LANDSCAPE PLAN - LOT 2,1-1

CLAREMONT BUSINESS PARK - 2
FILING NO. 1, LOT 1
7715 GARY WATSON POINT
COLORADO SPRINGS, 80915
EL PASO COUNTY, CO

JOB NUMBER	949-20
REVISIONS	
12-7-20	PER COMMENTS
ORIGINAL DATE	9-8-20
DRAWN BY:	JM
DESCRIPTION:	LANDSCAPE PLAN
SHEET NO.	L1.1

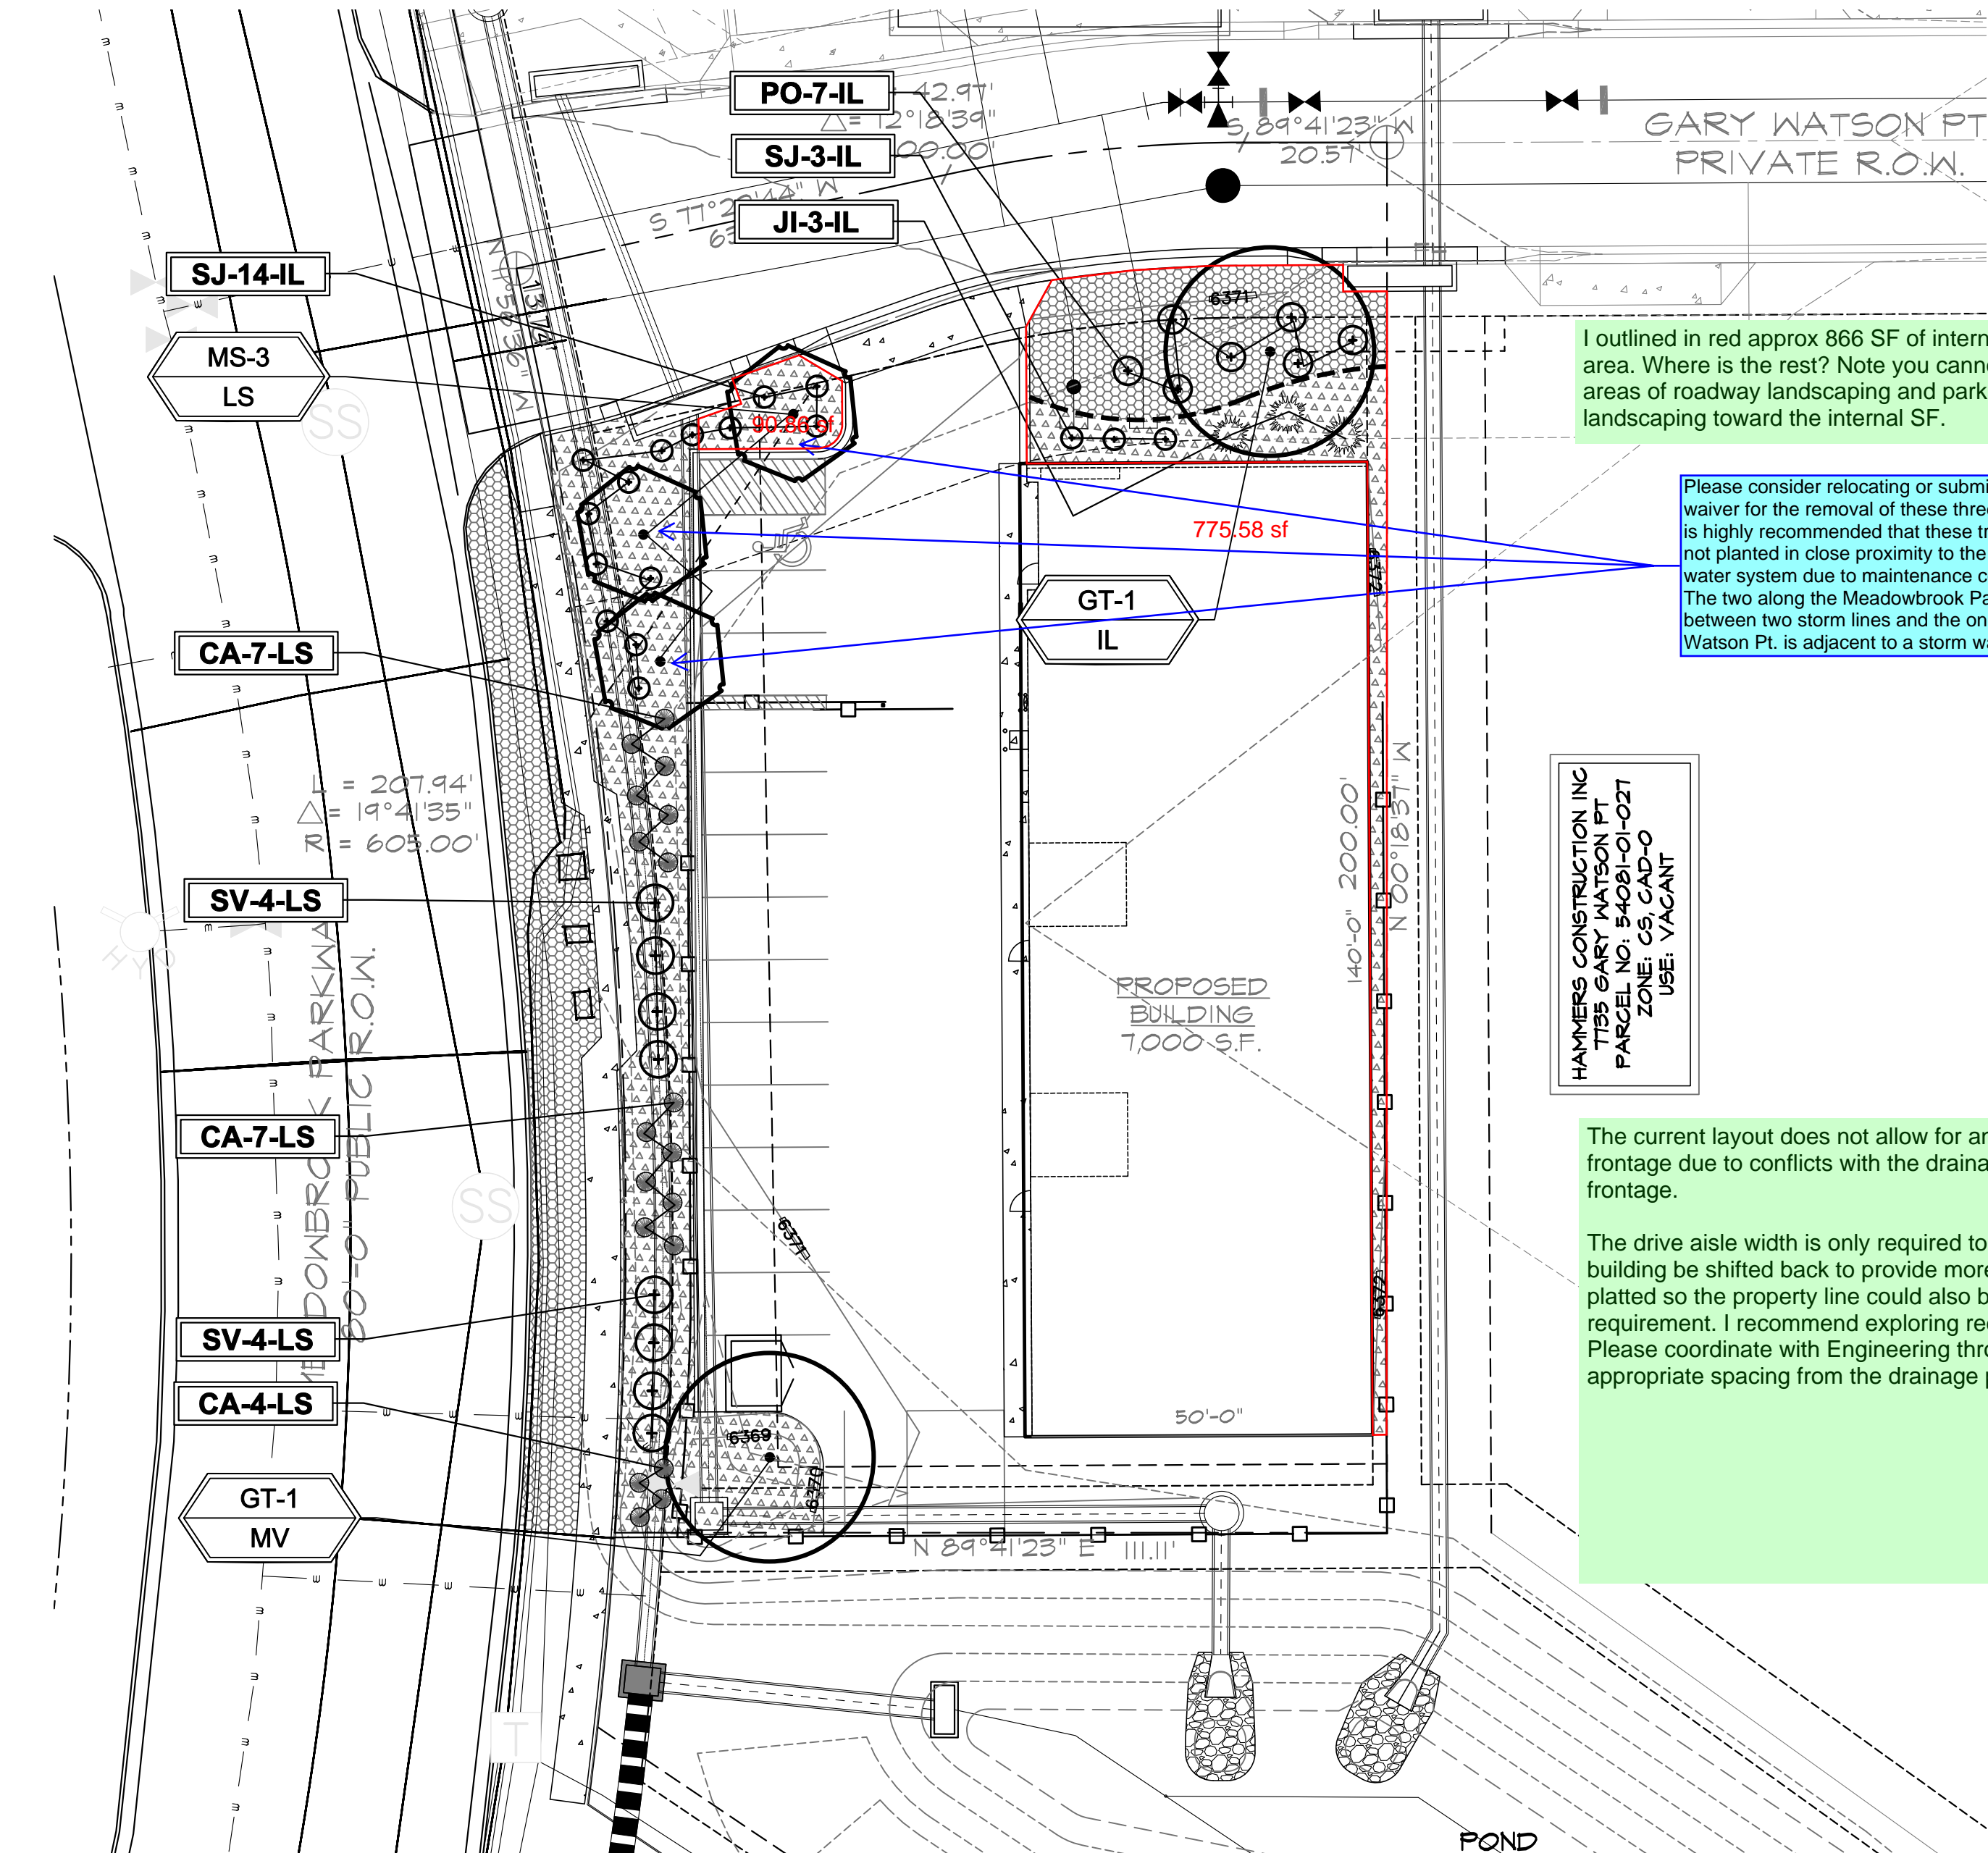
Only 4 trees are shown on plan? Please revise

See review comments #1 regarding Gary Watson Point roadway landscaping. Revise and include in table and on plans

Previous review comment not addressed: 15 shrubs are not shown on plan and only 10 are shown along Meadowbrook

Previous review comment not addressed, Internal landscape square footage appears to be unchanged and does not total 1500 sf.
